CITY OF ALBUQUERQUE

March 28, 2018

**Re: Primrose School
Erosion Sediment Control Plan
Engineer's Stamp Date –no stamp- (C13E029)**

ENGINEER'S SEAL RONALD R. BOHANNAN P.E. #7868	PRIMROSE SCHOOL OF NW ALBUQUERQUE	DRAWN BY pm
	SWPPP PLAN	DATE 3-20-18
		DRAWING
	 5571 MIDWAY PARK PL NE ALBUQUERQUE, NEW MEXICO 87109 (505) 858-3100 www.tierrawestllc.com	SHEET # 8
		JOB # 2017092

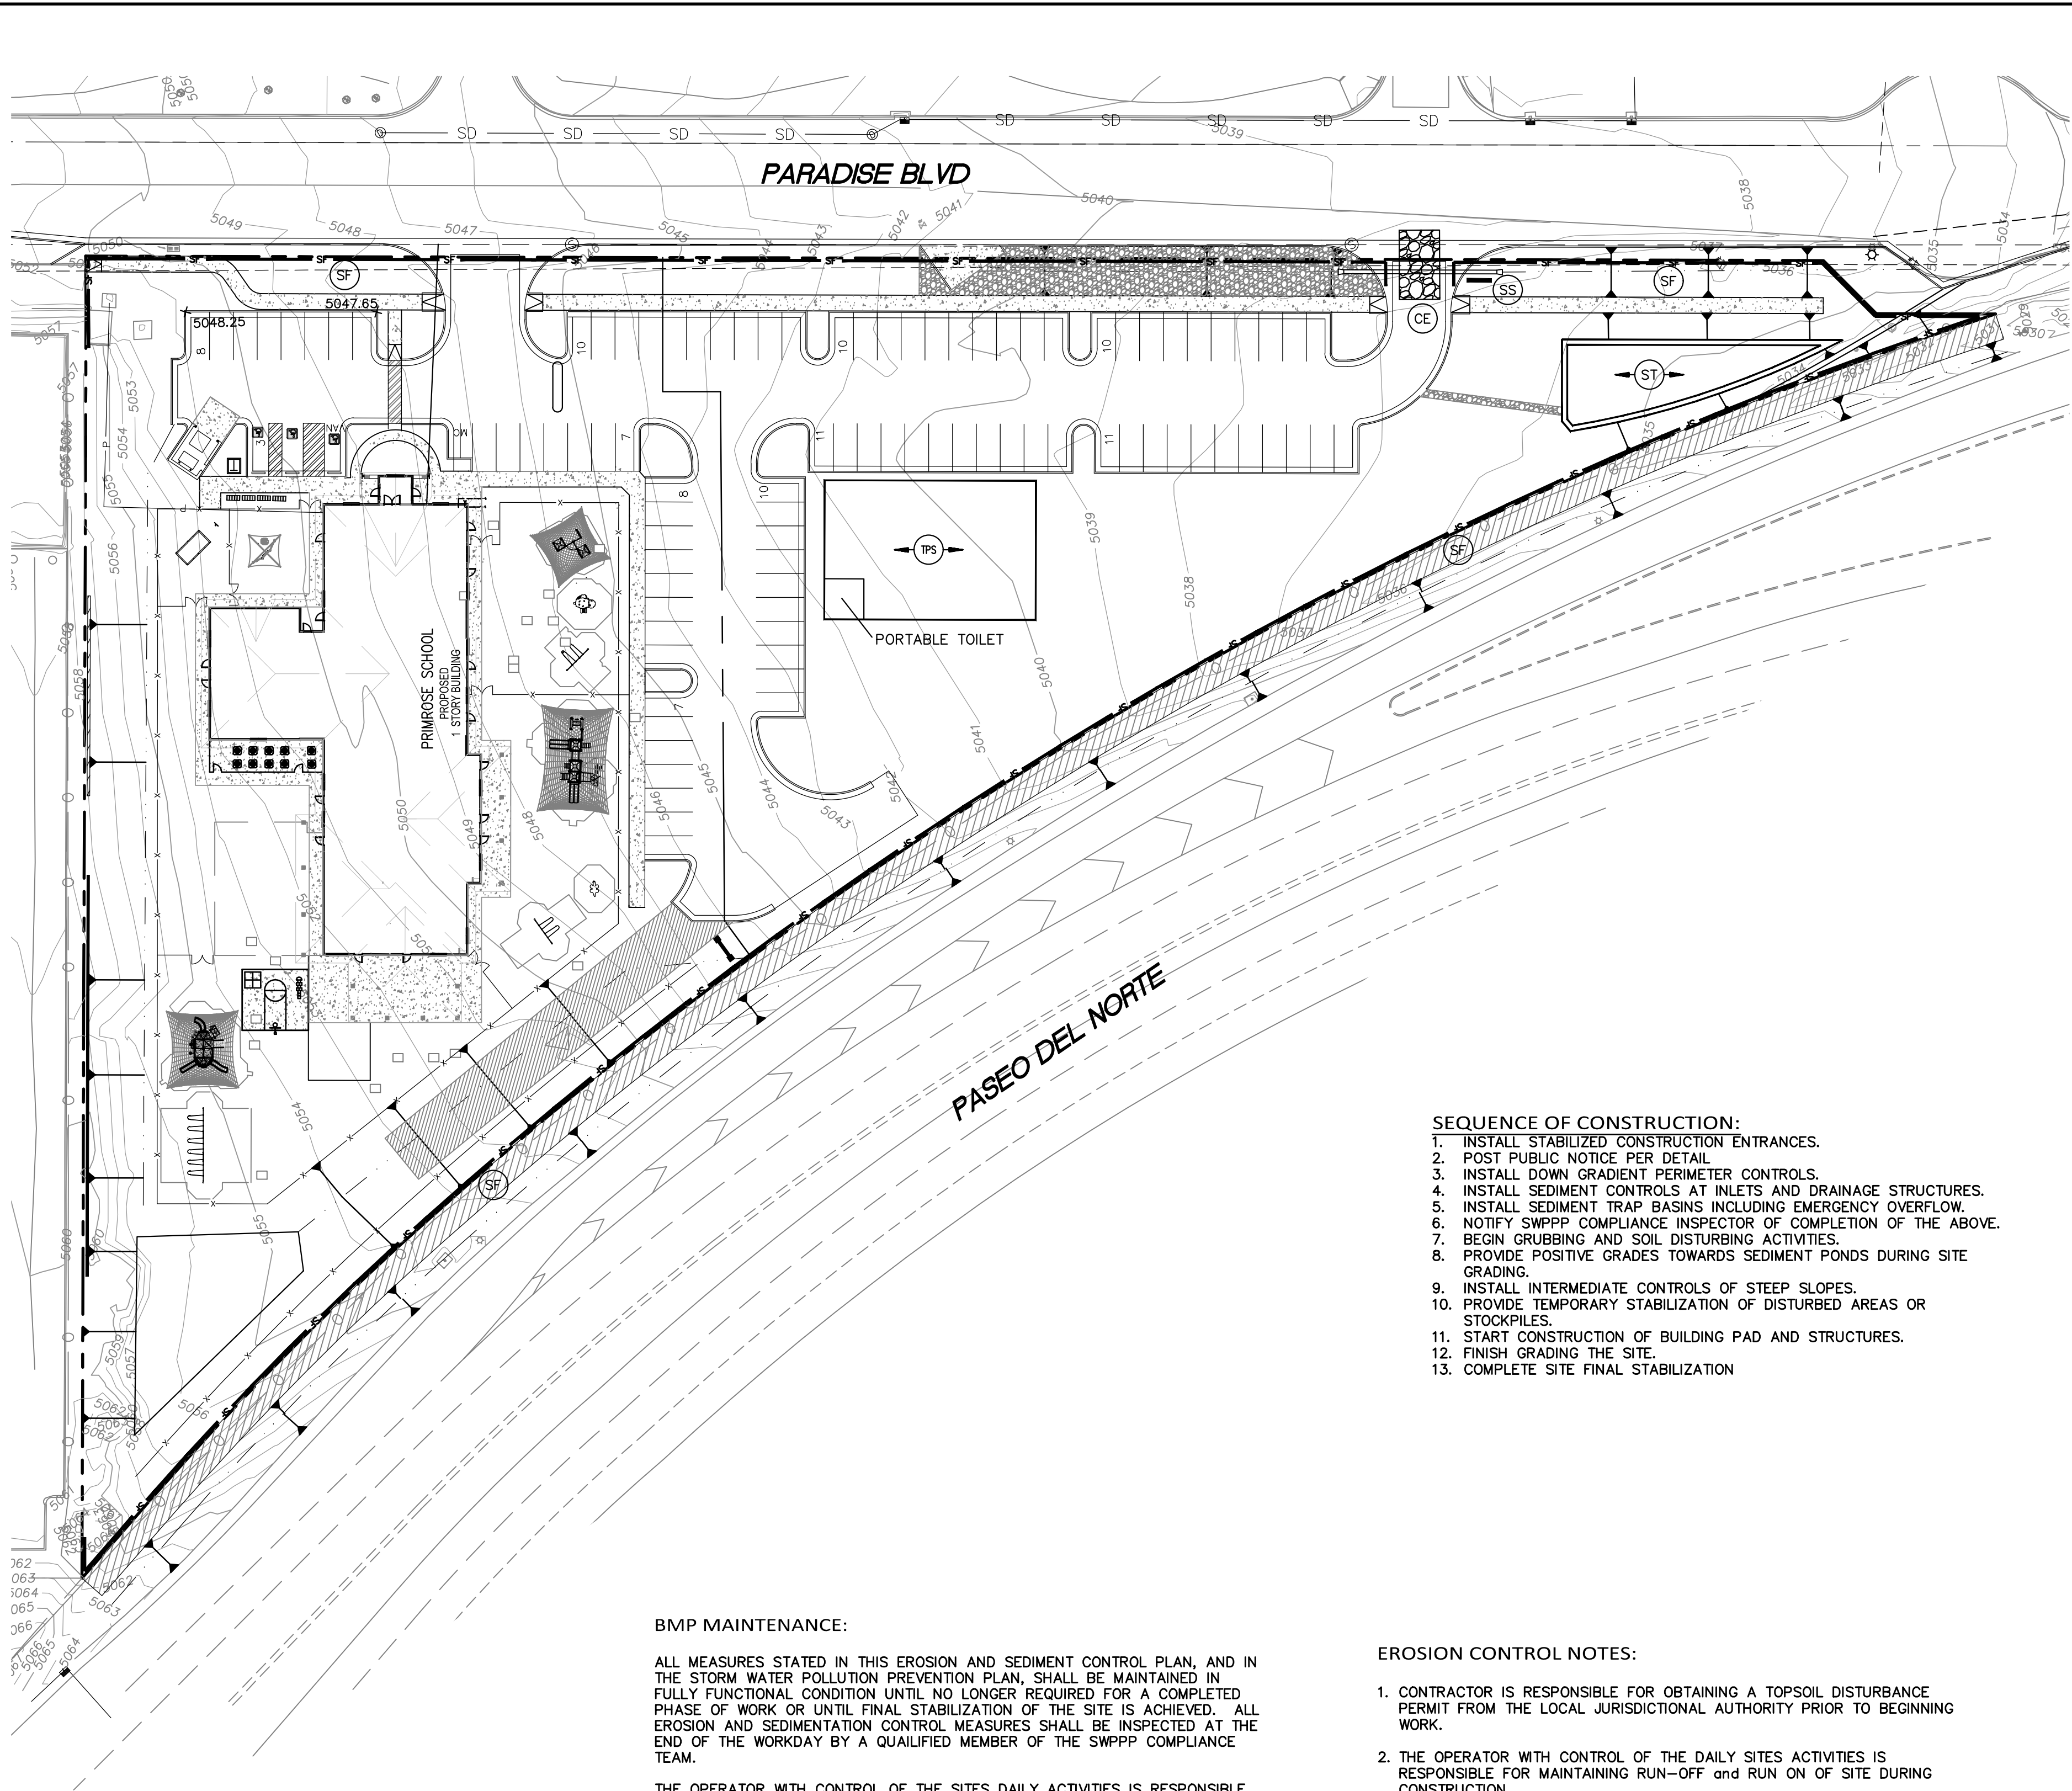
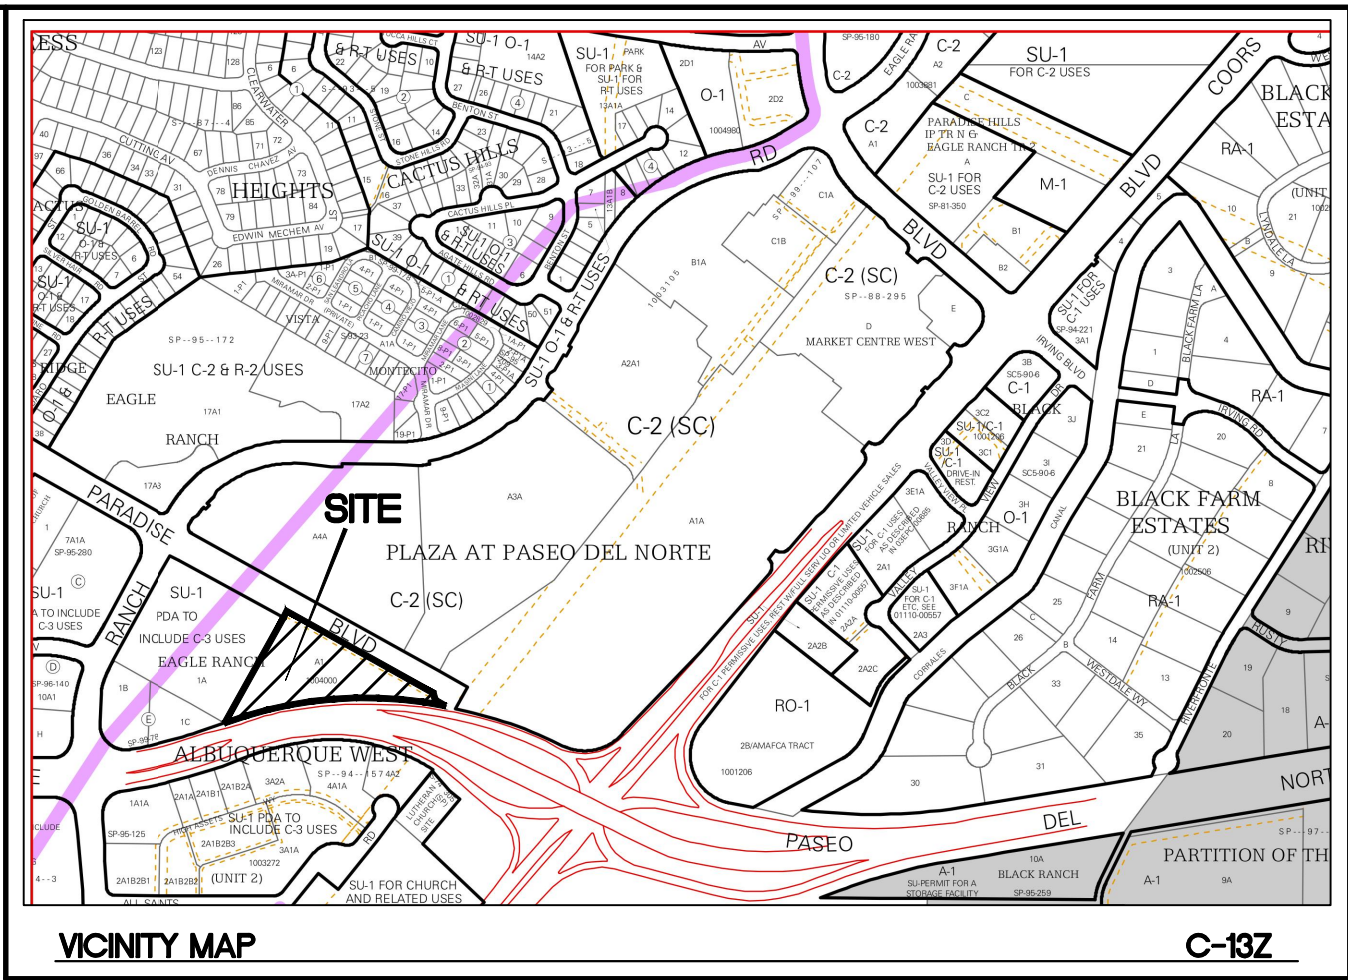
1. Provide proposed grades and drainage features. This is best accomplished by placing the BMPs on the grading plan that is submitted to Hydrology.

2. The plan is not sealed.
